From: Dawn Appleton [redacted]
Sent: 11 October 2017 16:33
To: Juan Baeza
Subject: RE: RE:

Further to our recent conversation please find attached the plan amended to show 30 caravans within the red edge the subject of this application and 60 as approved on the remainder of the site.

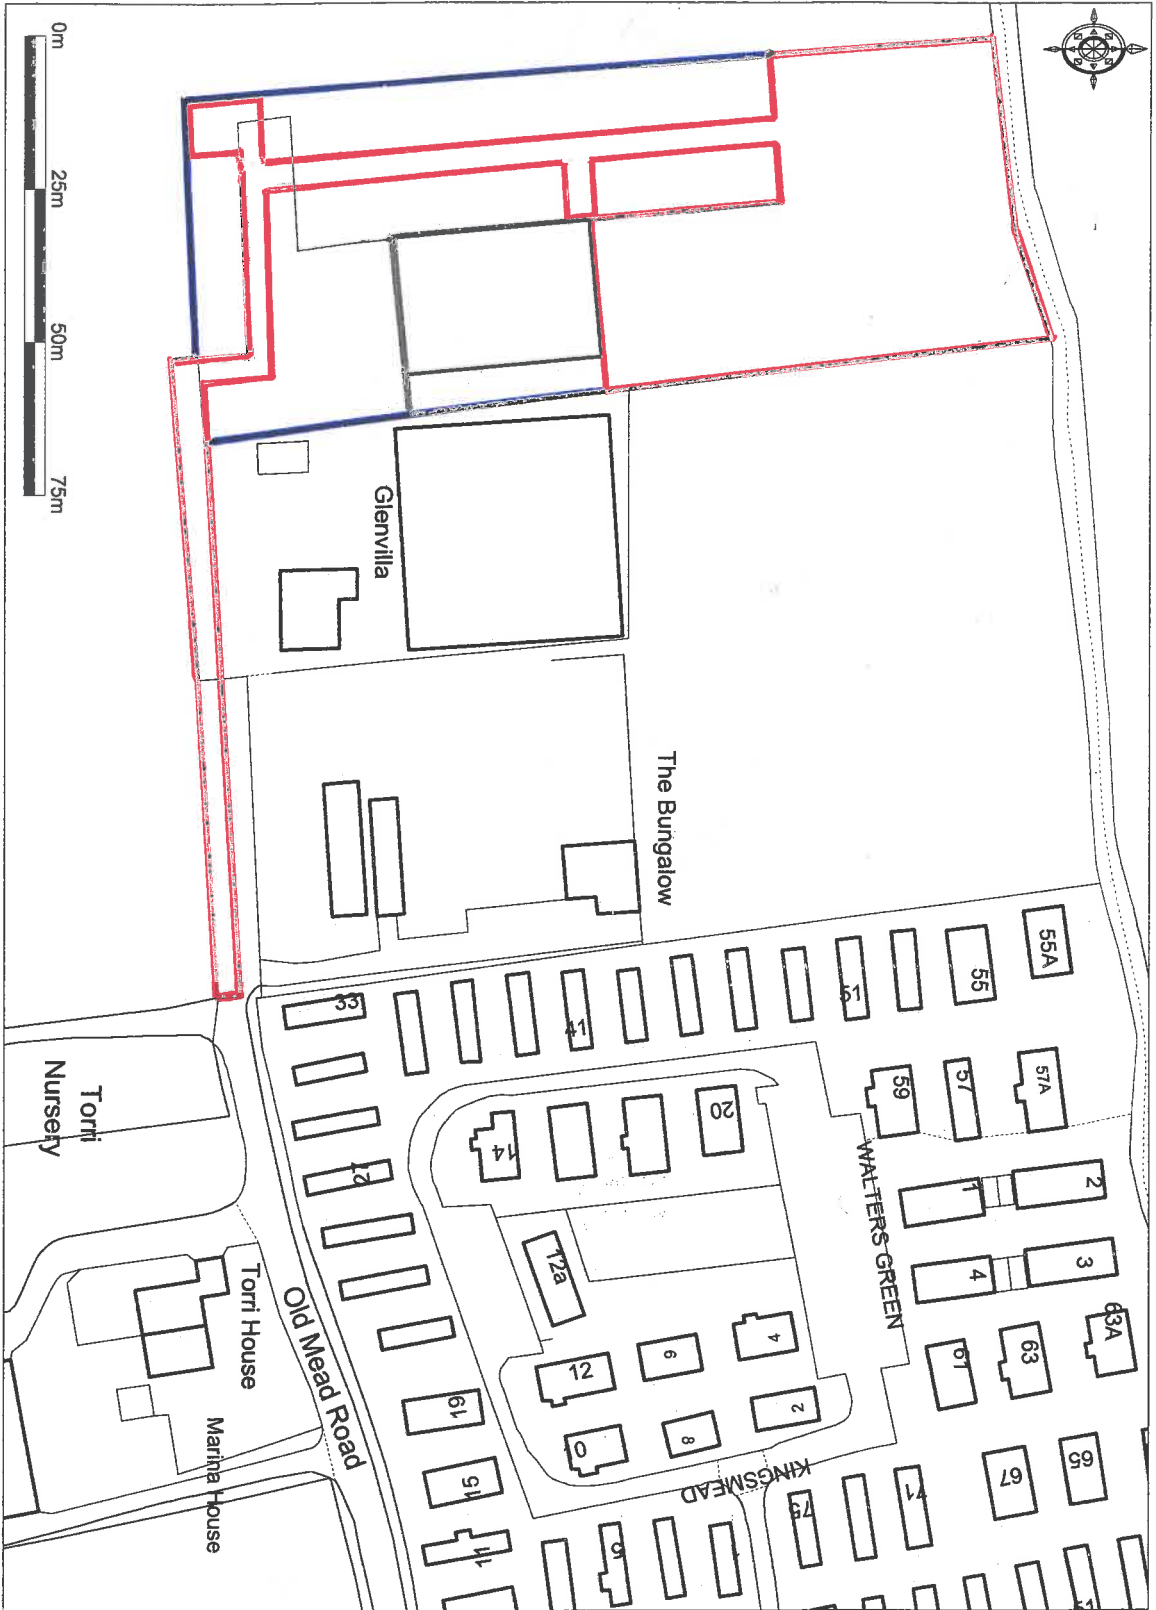
A couple of discrepancies. I have attached the site plan recommended to be approved under condition 2. When looking at the site plan the number of caravans along the western boundary is 29 and not 34 as denoted on the proposed landscaping plan. At the northern end its 9 not 10. Once you make these changes I can arrange to include it in the plans condition.
